Your Ref: SSD 7874

11 May 2020

**Re: Submission on behalf of One Darling Harbour _ Harbourside Shopping Centre
Redevelopment_SSD7874**

PODIUM ENVELOPE BELOW  
SEE DRAWING SSDA1-100  
ENVELOPE PLAN - PODIUM

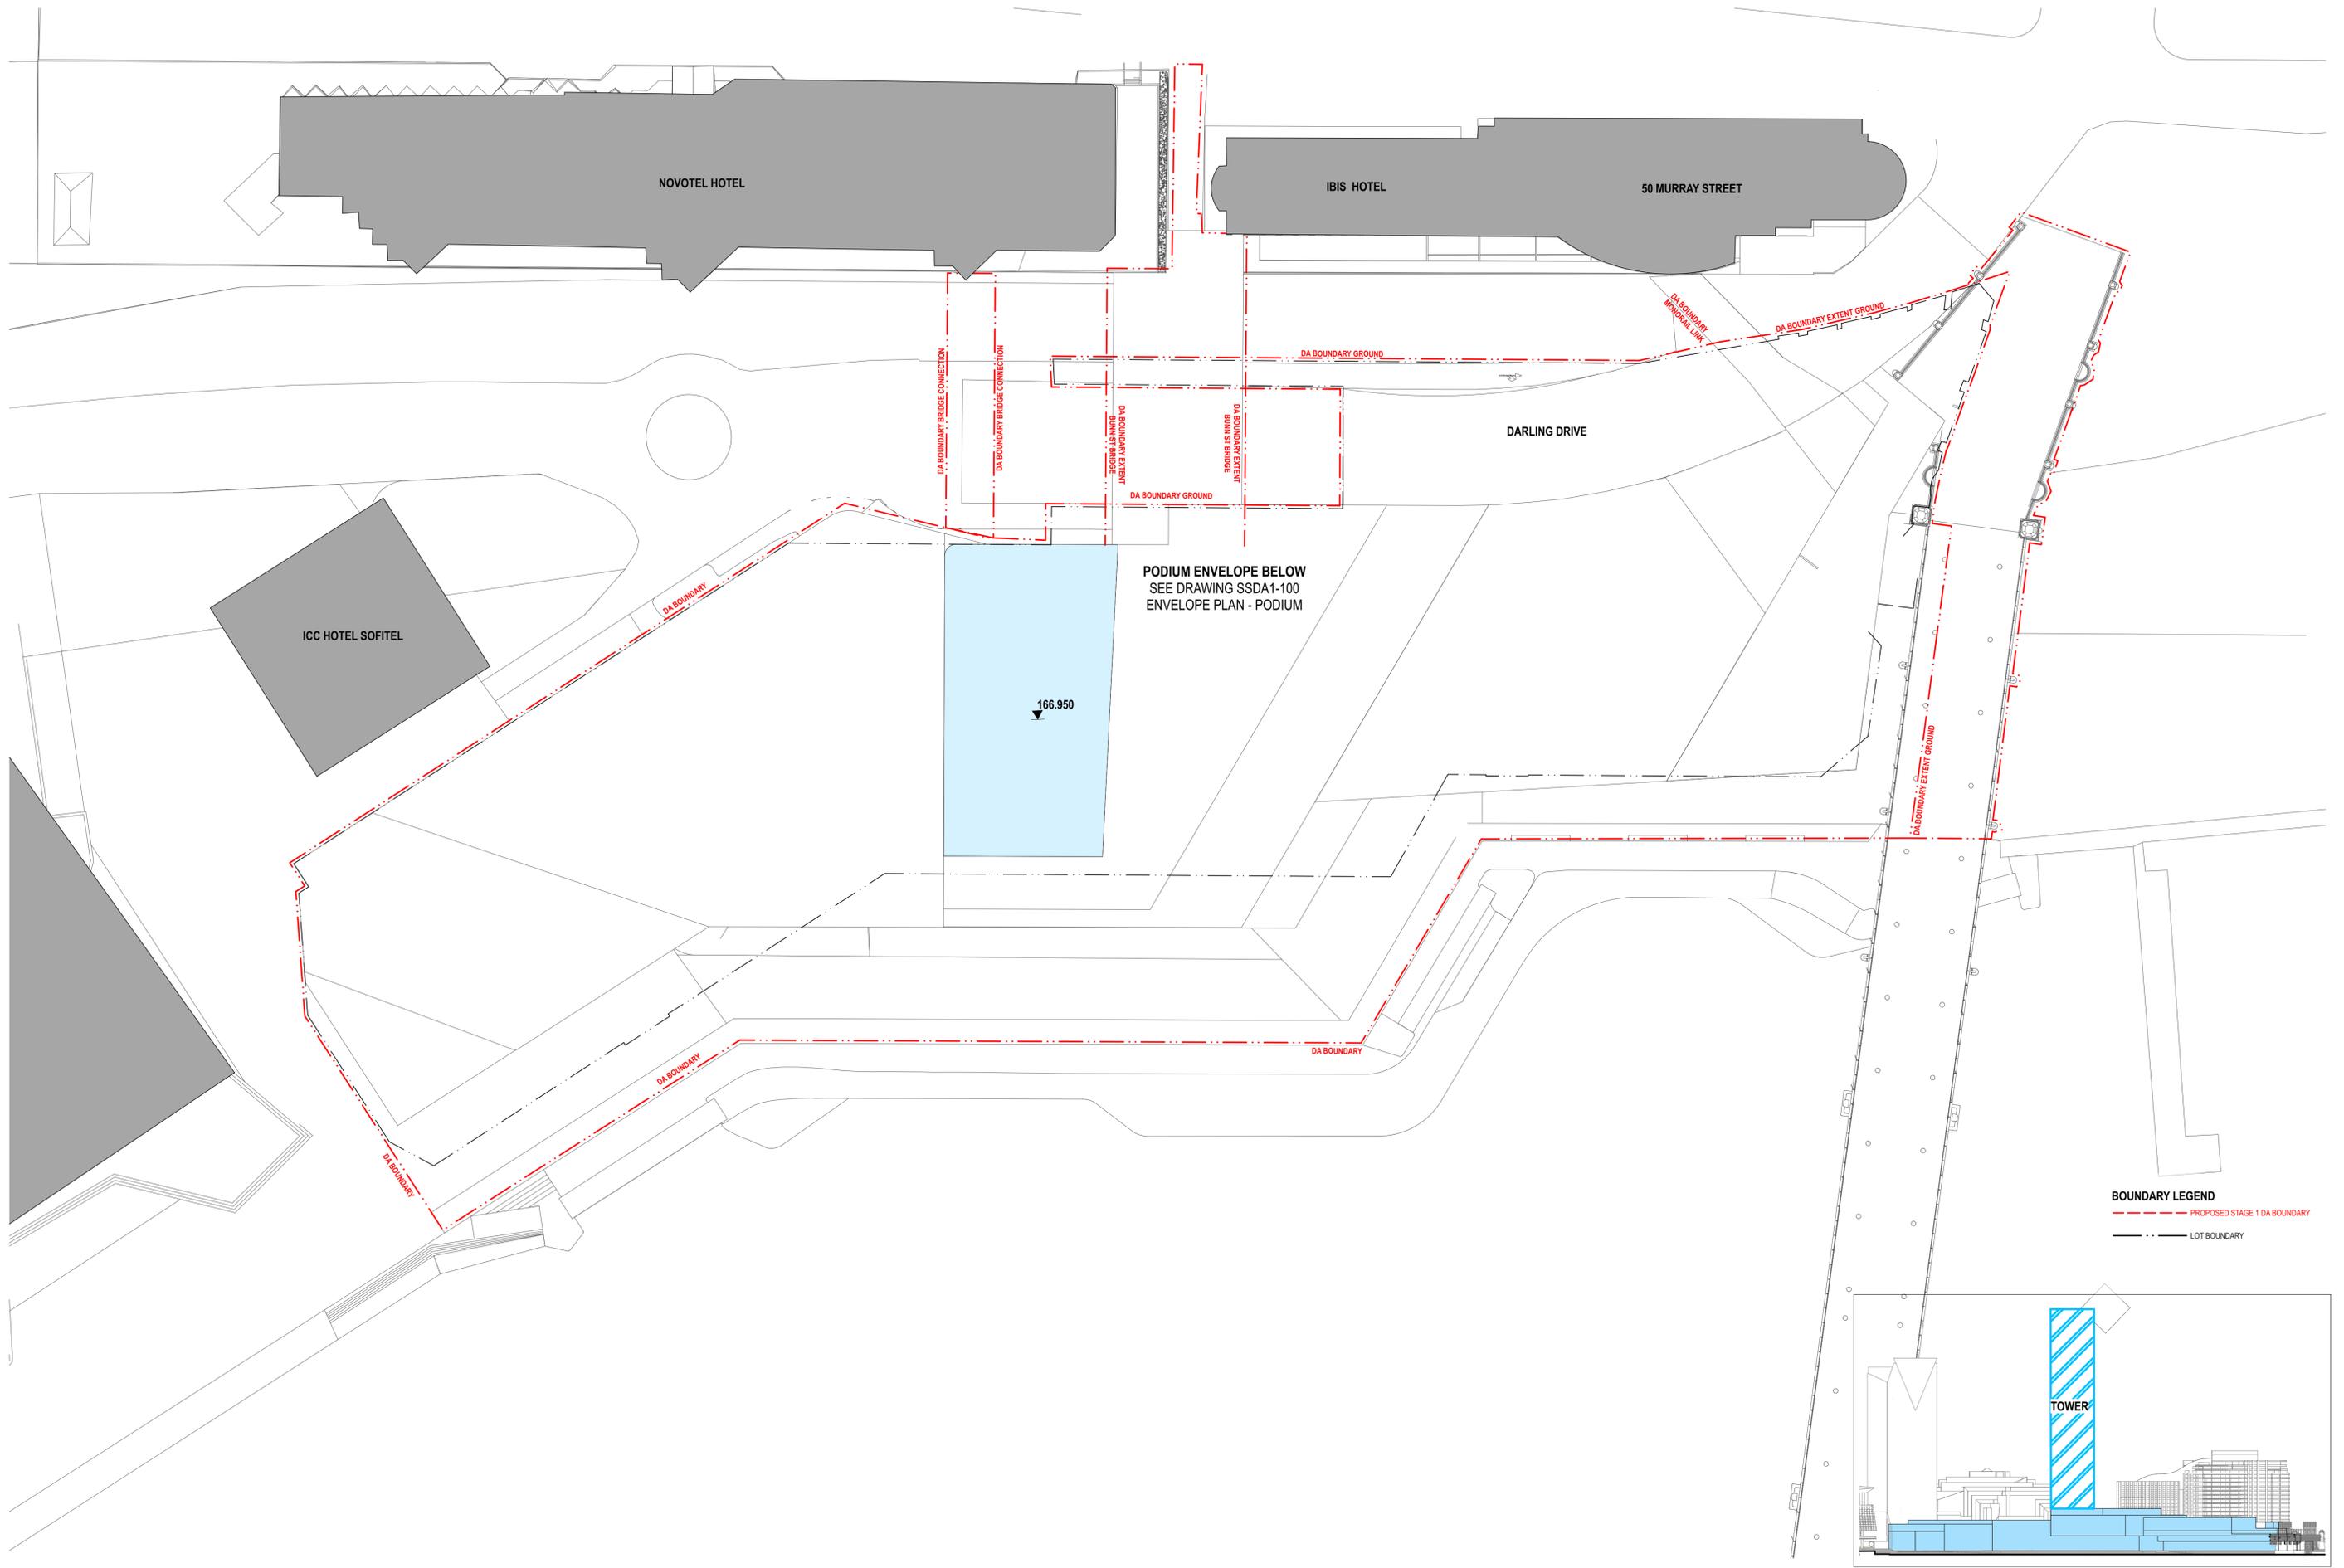
- The proposed building envelope will almost touch the envelope of the pedestrian walkway of Pyrmont Bridge;
- The relative height of the bridge is not specified. However, it appears that the pedestrian walkway of Pyrmont bridge is between 11.5m RL- 13.m RL and the railings are at between 12.5m-14m RL⁵.
- The northern podium will be primarily at 25m RL. The podium will be approximately 7m distant from the bridge at this height. The "lower" triangular segments of the podium (which sit closer to the bridge) are to be 16.5m RL (on the harbourside) and 17.5m west of the bridge buttresses. The height of the proposed podium sliver most directly adjacent to the bridge is not specified.

The podium areas closest to the bridge are actually **higher** in this proposal than in the original proposal. In the original proposal the majority of the northern podium was to be 23.8m RL.

An extract from the "Envelope Plan – Podium" dated 11/2/20 is provided below⁶:

- It is unclear what part of the podium envelope the author considers will have 10m separation from the bridge. Analysis of the proponent's podium envelope plans suggest that the northern podium envelope will touch the bridge envelope and is at widest only approximately 4m from the bridge. Perhaps the author has had regard to the artist's impressions (eg Figure 2.1 in the report) when assessing this impact.

SECTION ENVELOPE Section 1  
1:500

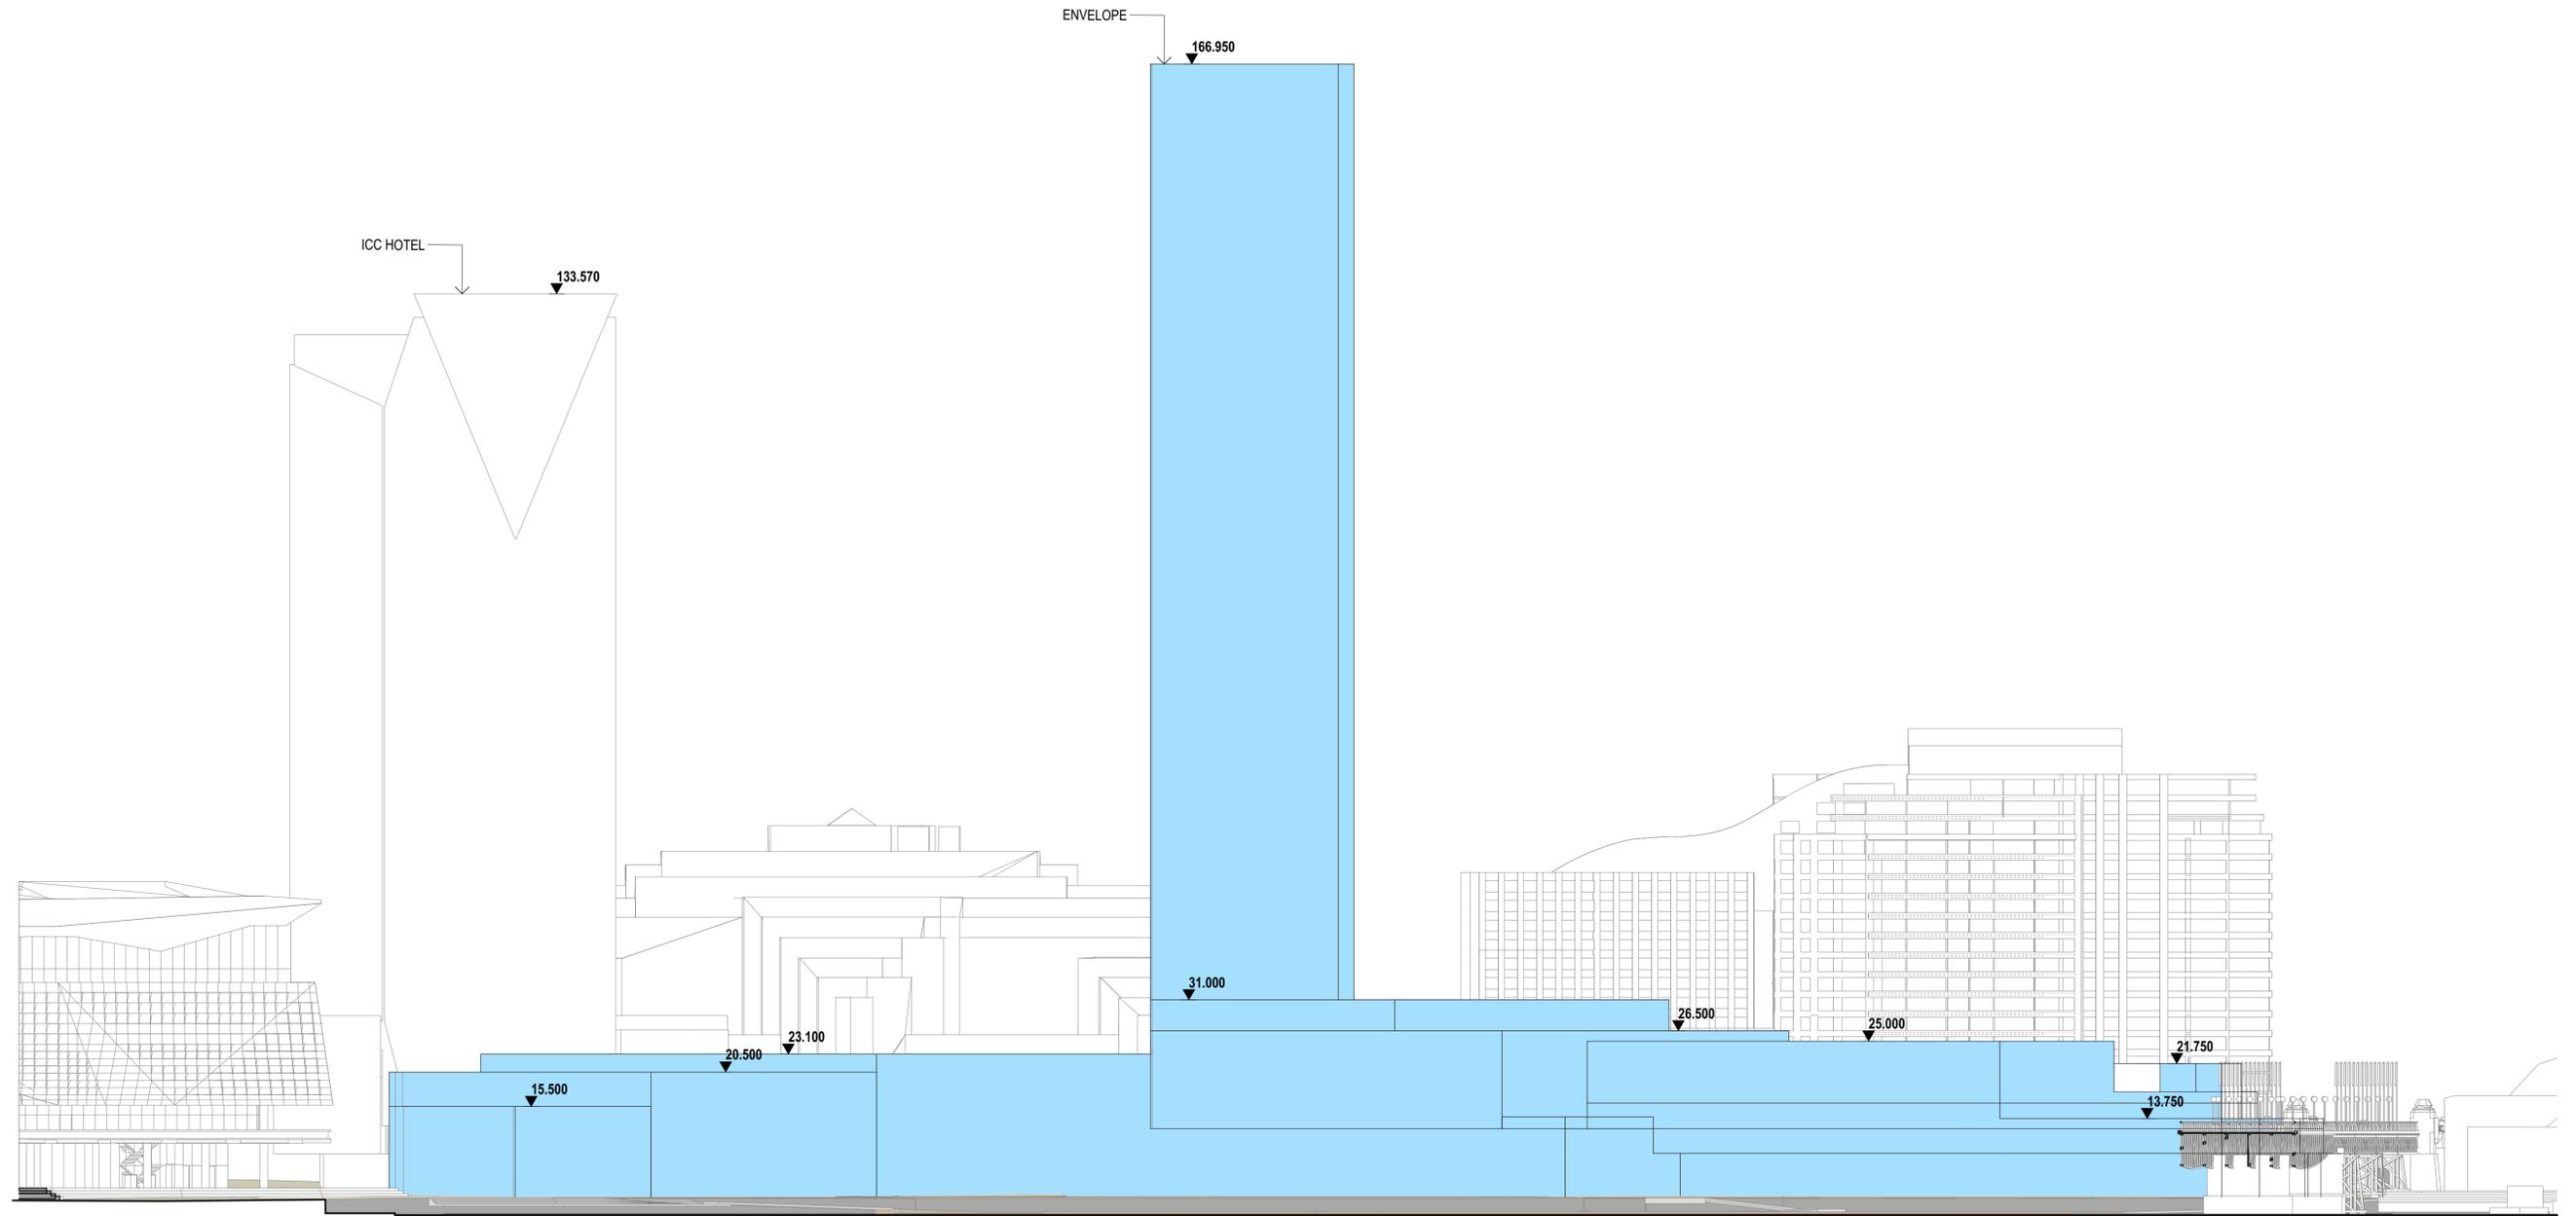
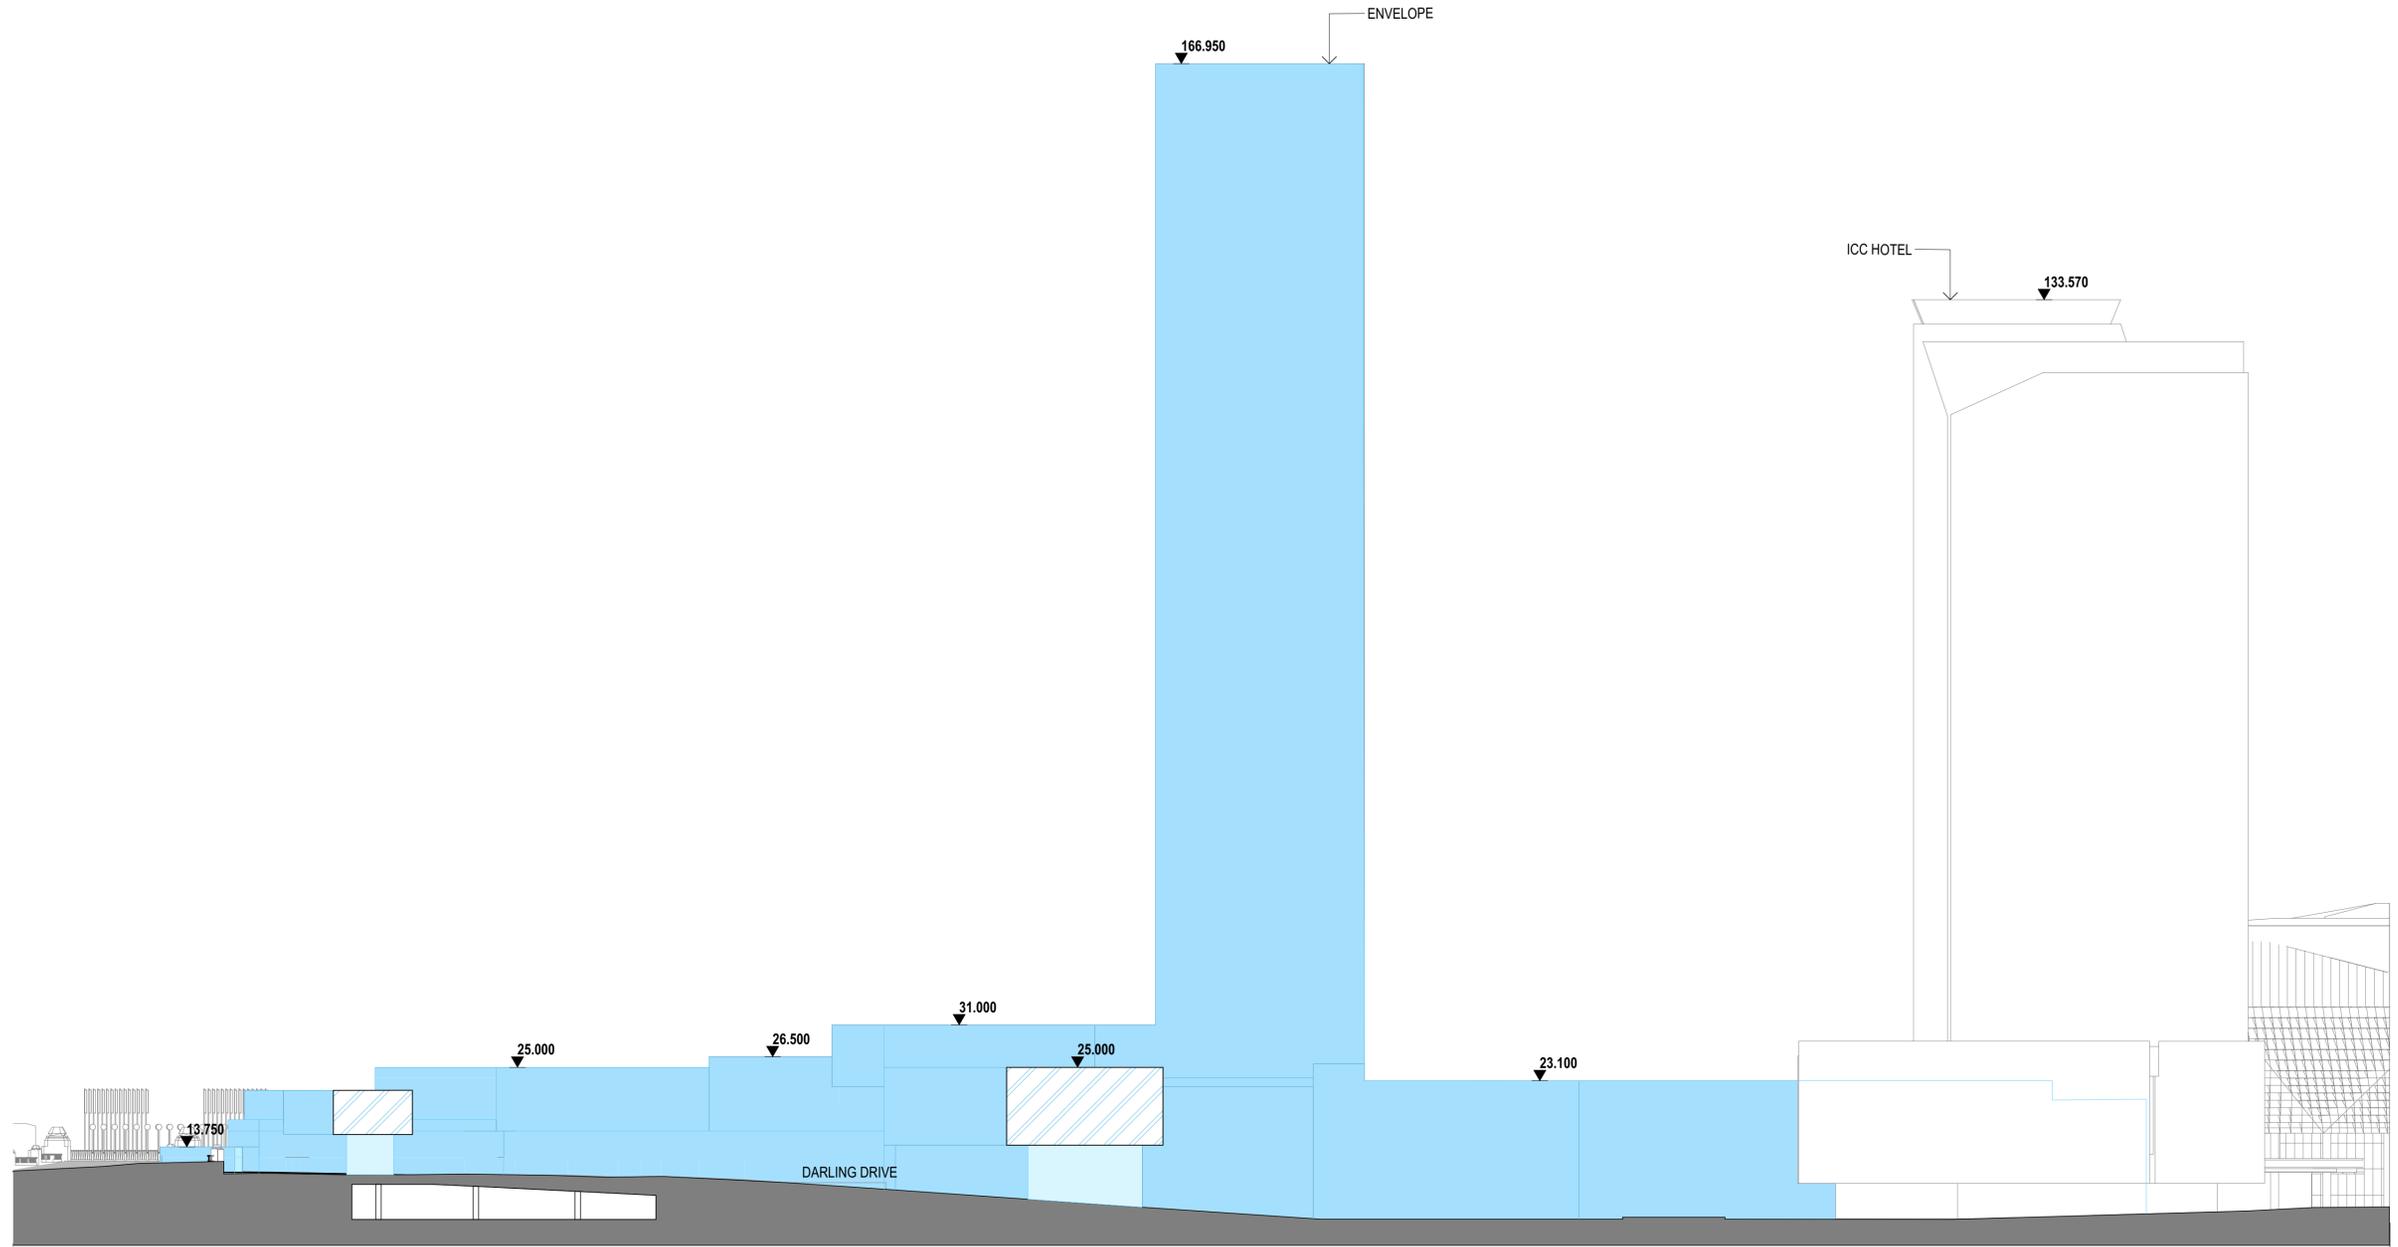
The proposed northern podium envelope will adjoin Pyrmont Bridge and due to its height and proximity, will visually overshadow the bridge and its setting. The extent of the impact is difficult to discern from the information provided by the proponent due to

- The discussion at section 4.4 of the VVIA suggests that the podium element is of low to medium scale. The northern podium is the height of a 7+ storey residential building, over twice the height of Pyrmont Bridge.
